V2_Site Development Plan_COMMENTS.pdf Markup Summary

The Ascent Church Site Development Plan

Addition and Remodel

1750 Deer Creek Rd Monument, CO 80132

1 SDP - SITE PLAN & PARKING PLAN
1" = 50'-0"

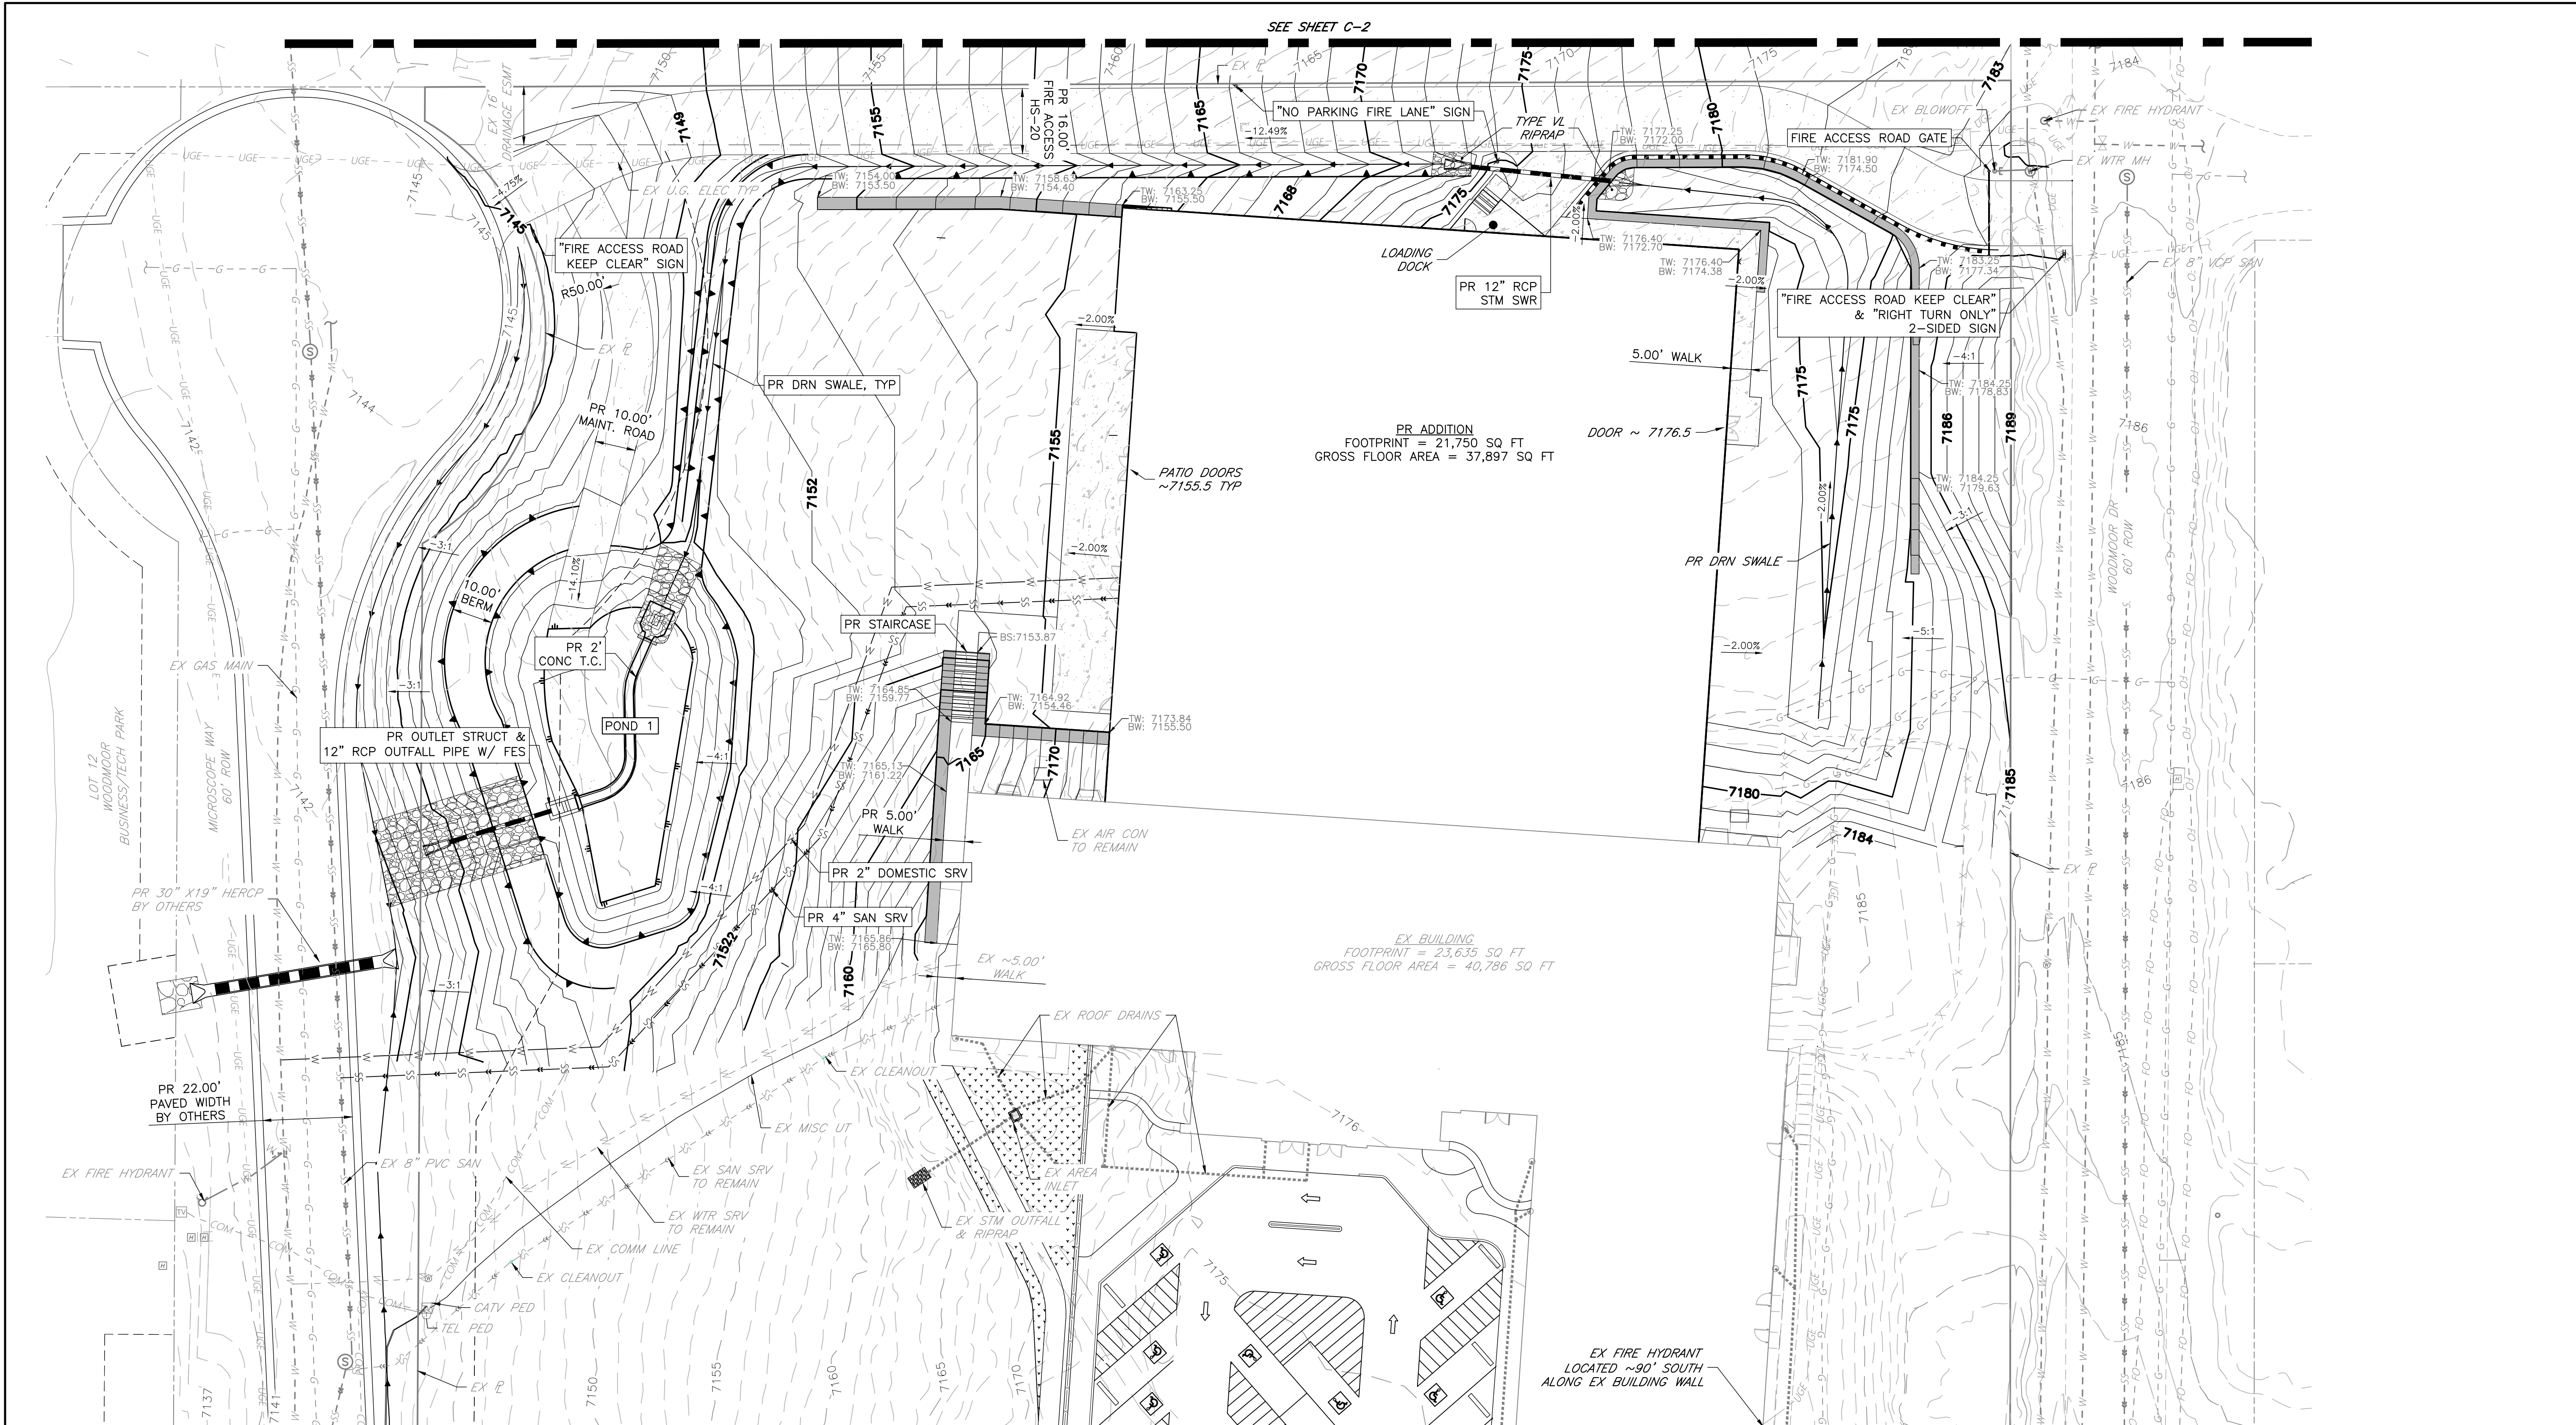
Please include
drainage easement
around the pond

please indicate height of retaining wall. Details not provided

Provide details regarding the agreed upon improvements to be installed by the private contractor. (Ex: Preliminary design alongside agreement with contractor.) Redacting financial info is fine, but Planning needs to verify that parking lot islands, landscaping, and lighting will be brought into compliance.

C-1 OF 12

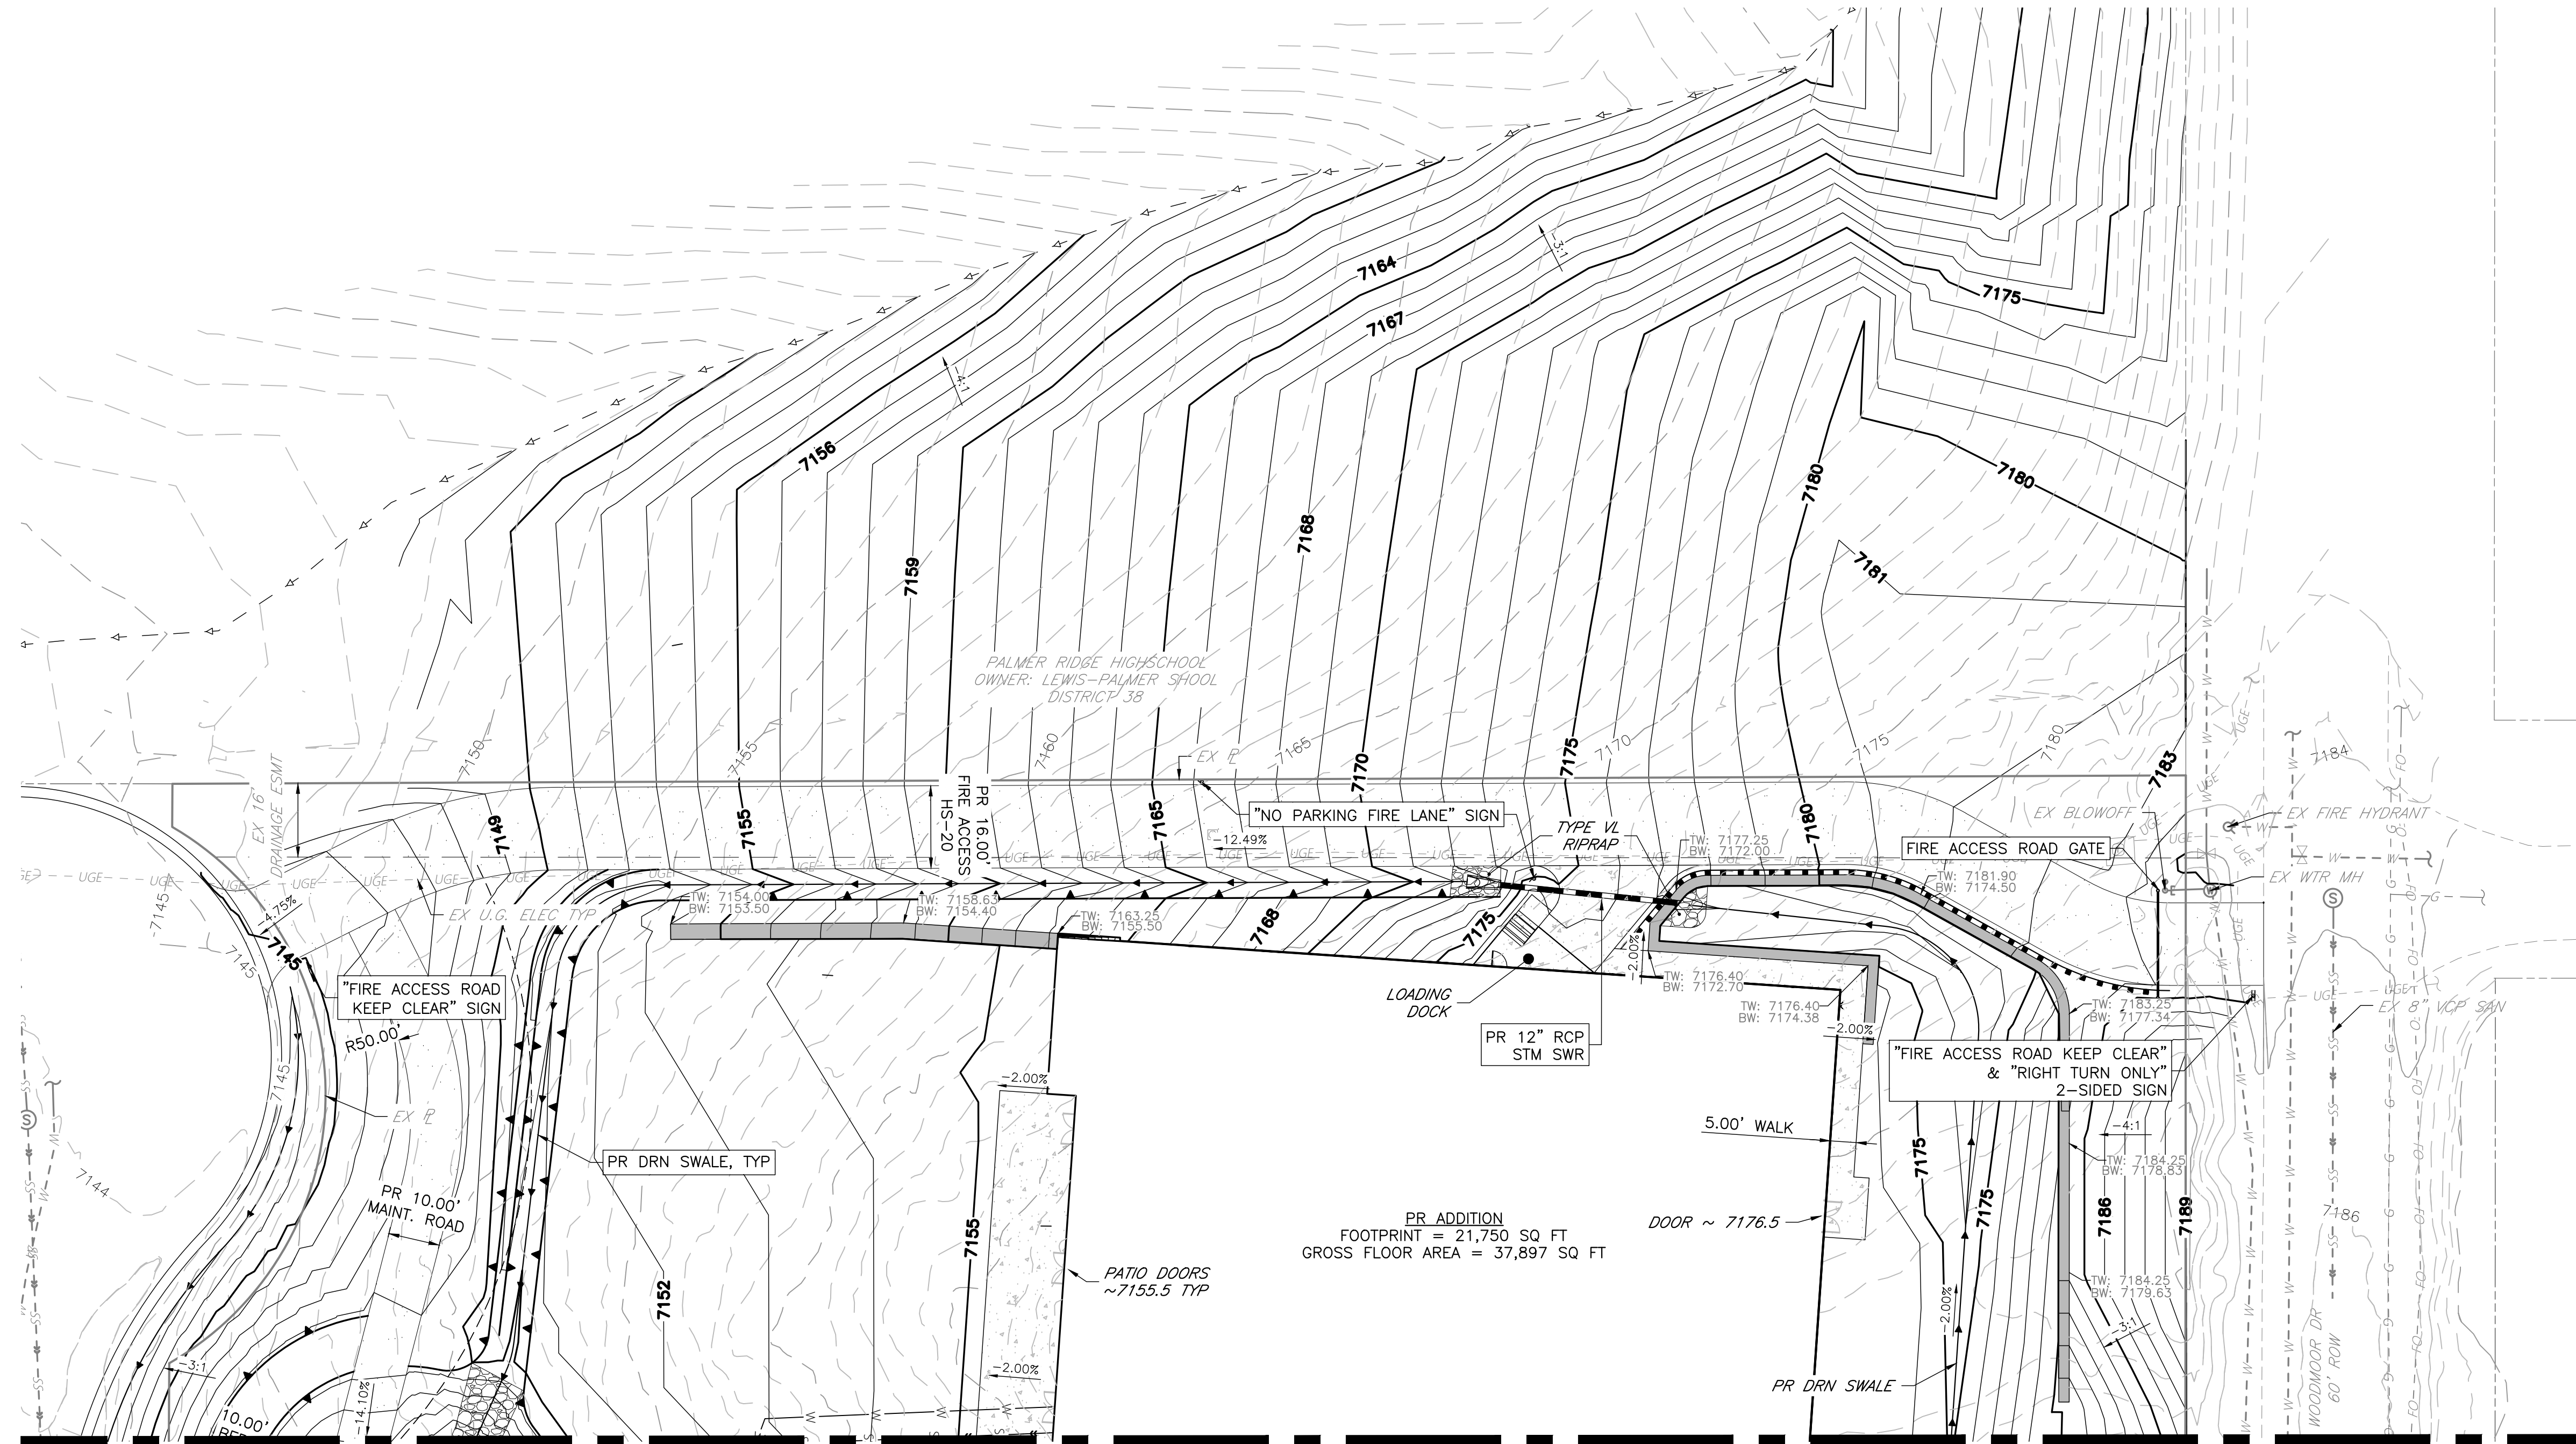
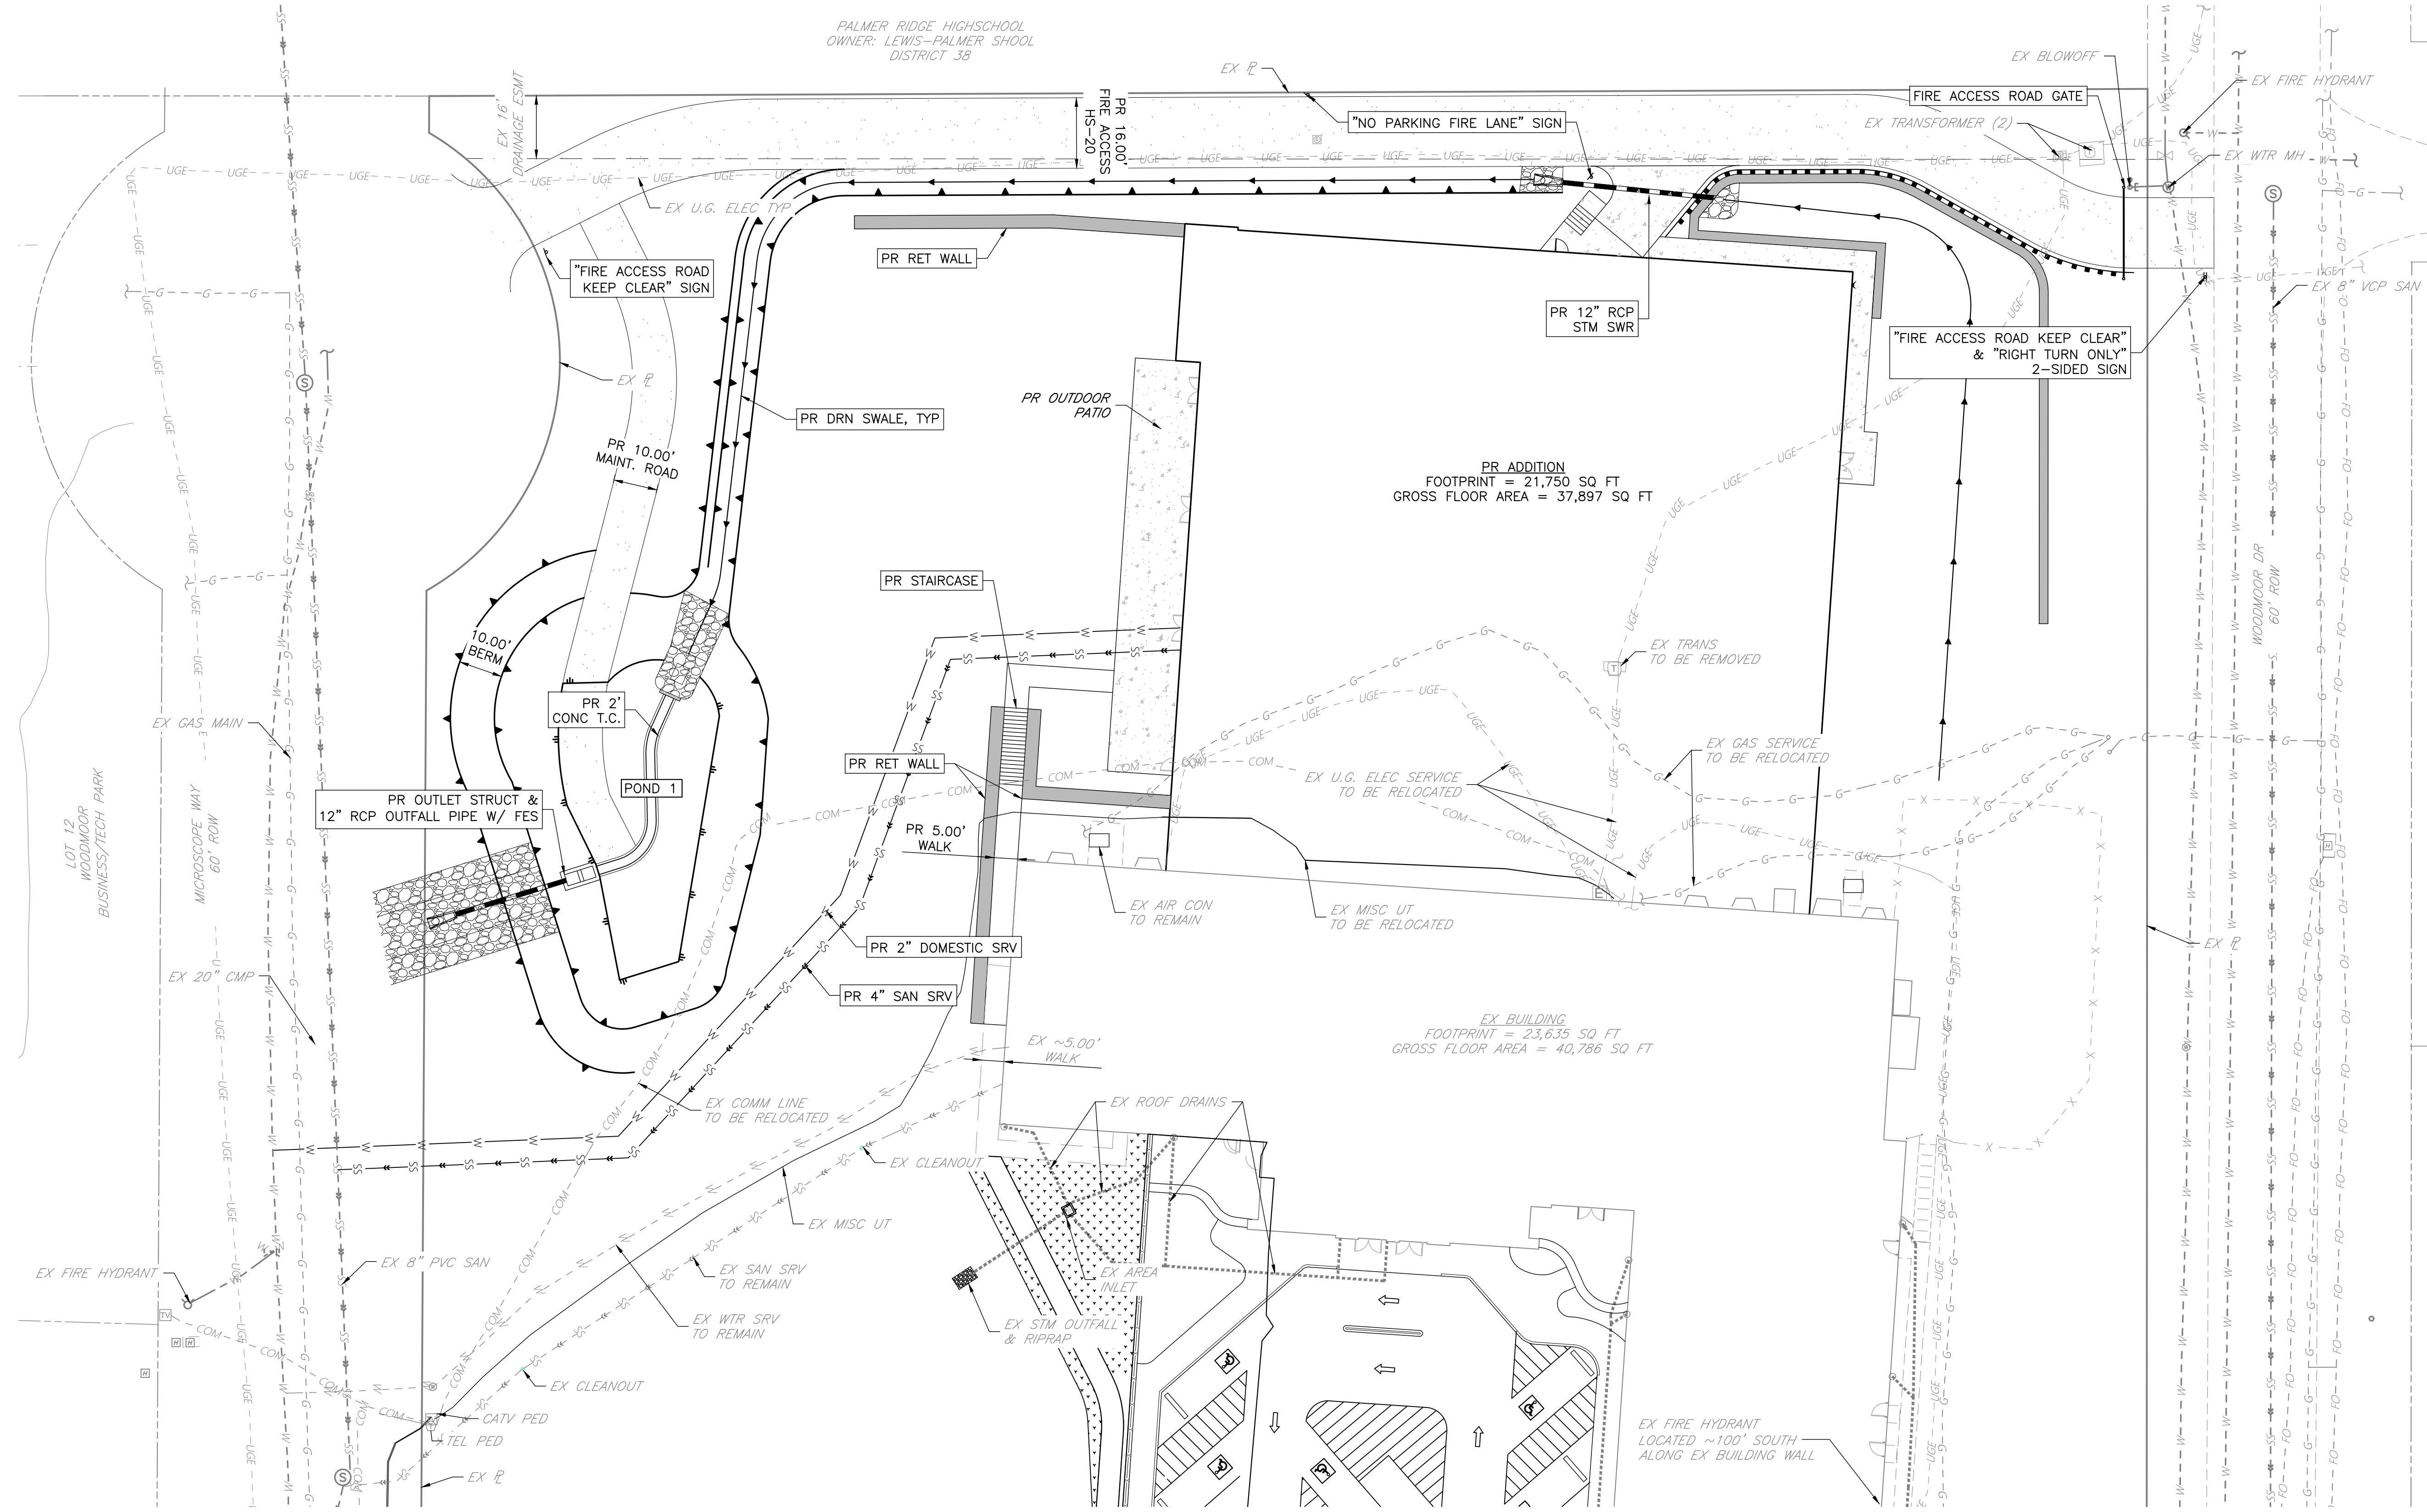
To be included with
GEC plan sheet set
and removed from
SDP set

NOTE: Walls over 4 ft require a building permit.

ACTION: Walls over 7 ft are considered an accessory structure and shall meet setbacks (25 ft).
